El Paso County Stormwater Management Plan Checklist

Project Name: Legacy Church **Date and Reviewed By:** 7/19/19 - EJG

C2.0

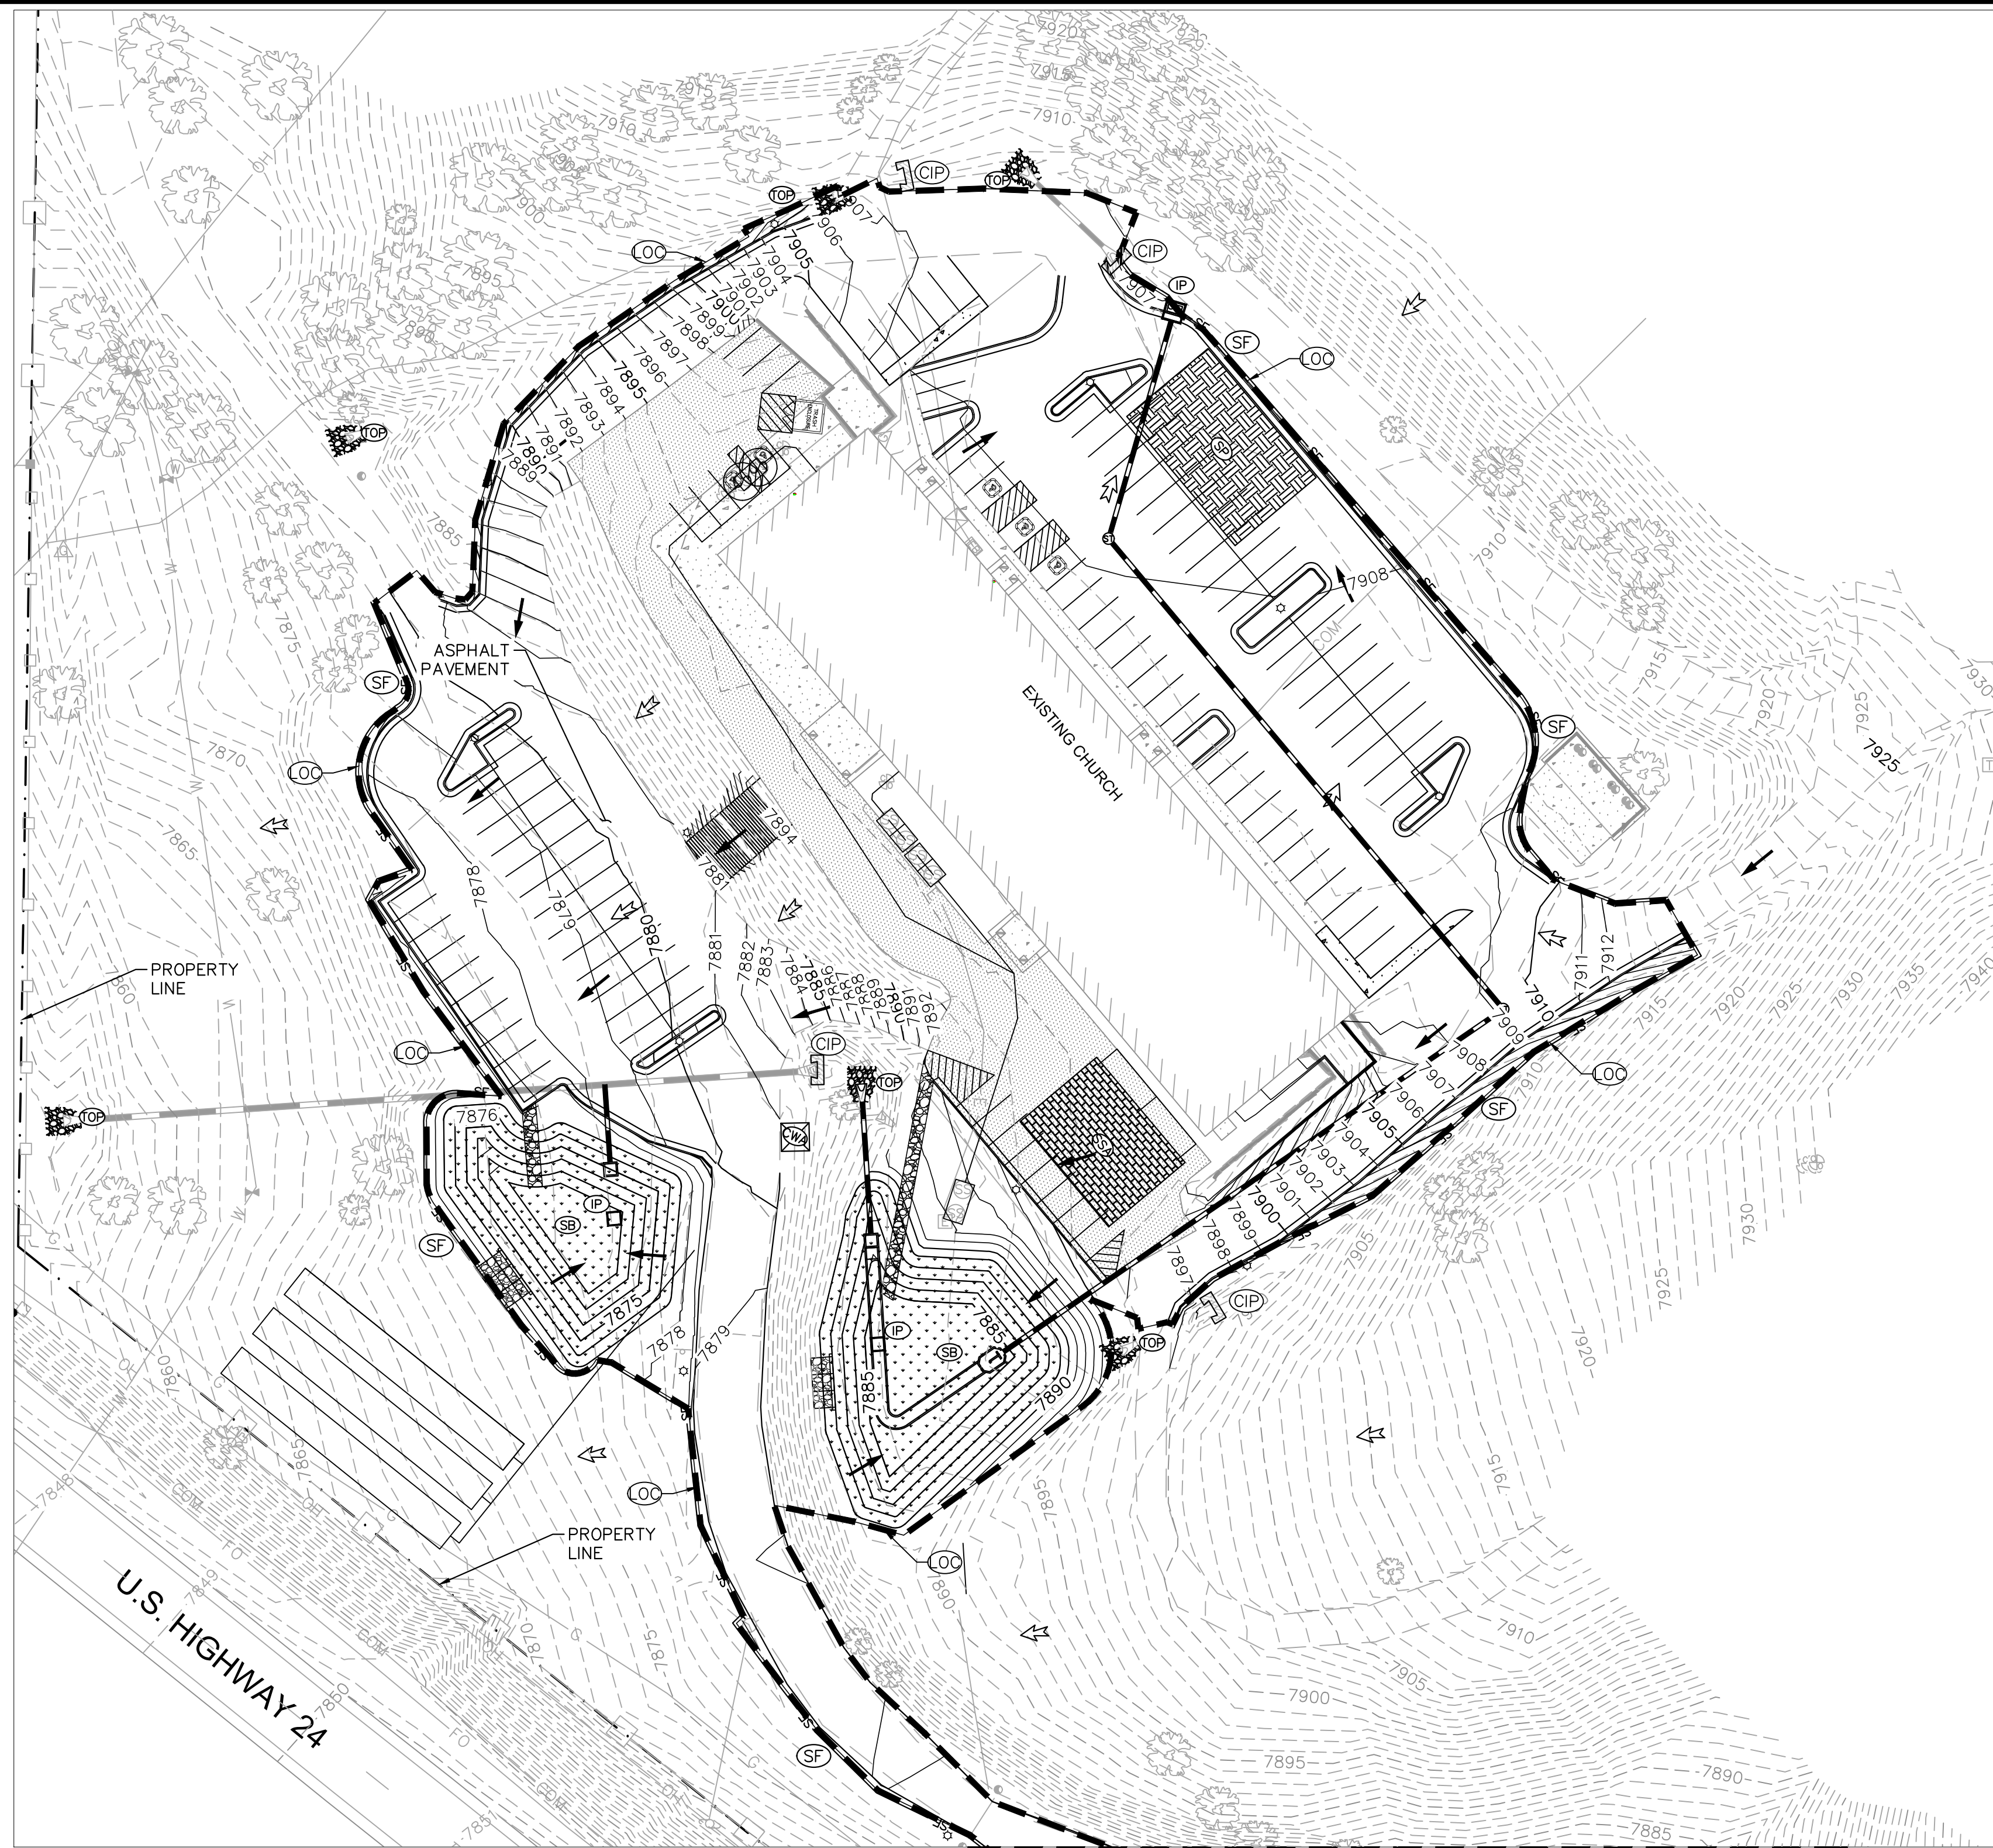
please provide

please provide

expected date on which the final stabilization will be completed
